PLANNING CONSULTATION RESPONSE

Application No	2026/0269
Proposal	Display of freestanding illuminated totem front sign. (Advertisement Consent)
Address	10 Wombwell Road, Platts Common, Barnsley, S74 9SQ
Date of Consultation Reply	22 nd May 2026
Consultee	Highways DC

SIGN FRONT & REAR ELEVATIONS
SCALE 1:100 AT A3

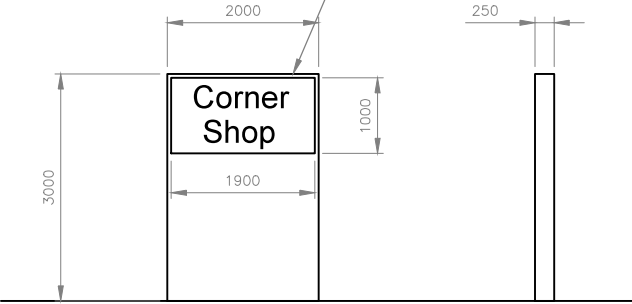
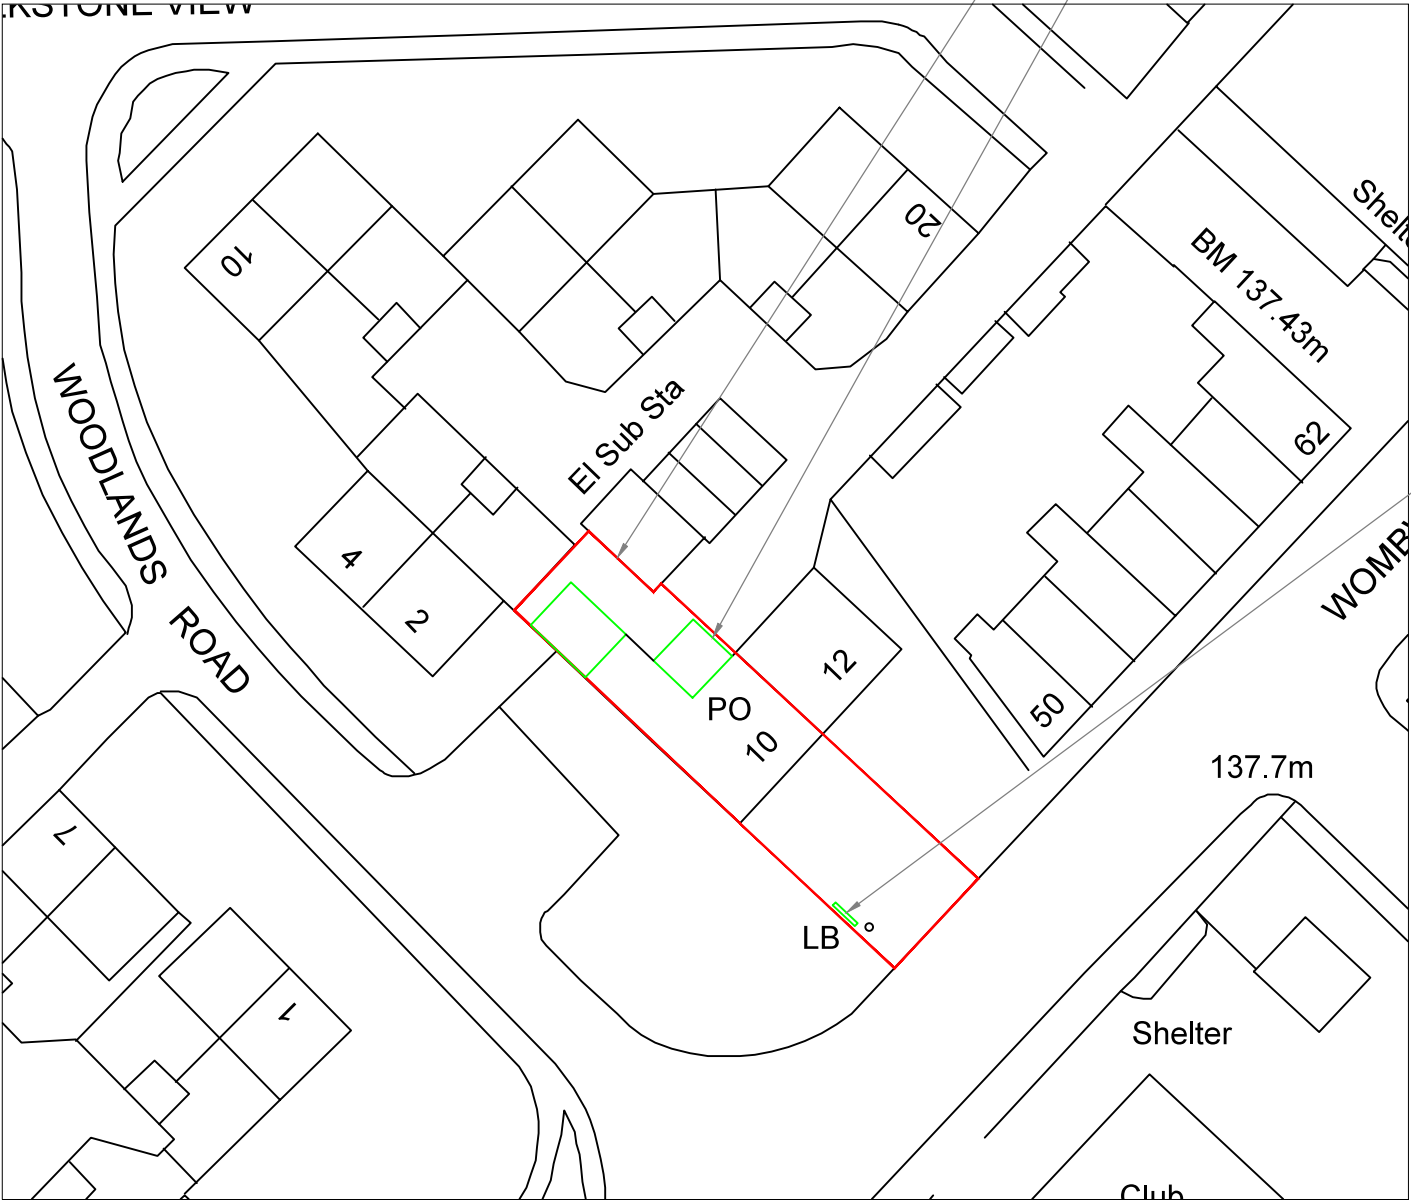
The proposed illuminated totem sign would be positioned back from the public highway and well above head height, as such, it is considered that it would not adversely impact upon any vehicular or pedestrian sight lines/visibility nor constitute an undue distraction to road users. The totem sign is to have a proposed maximum luminance of 300cd/m² which is within recommended maximum levels.
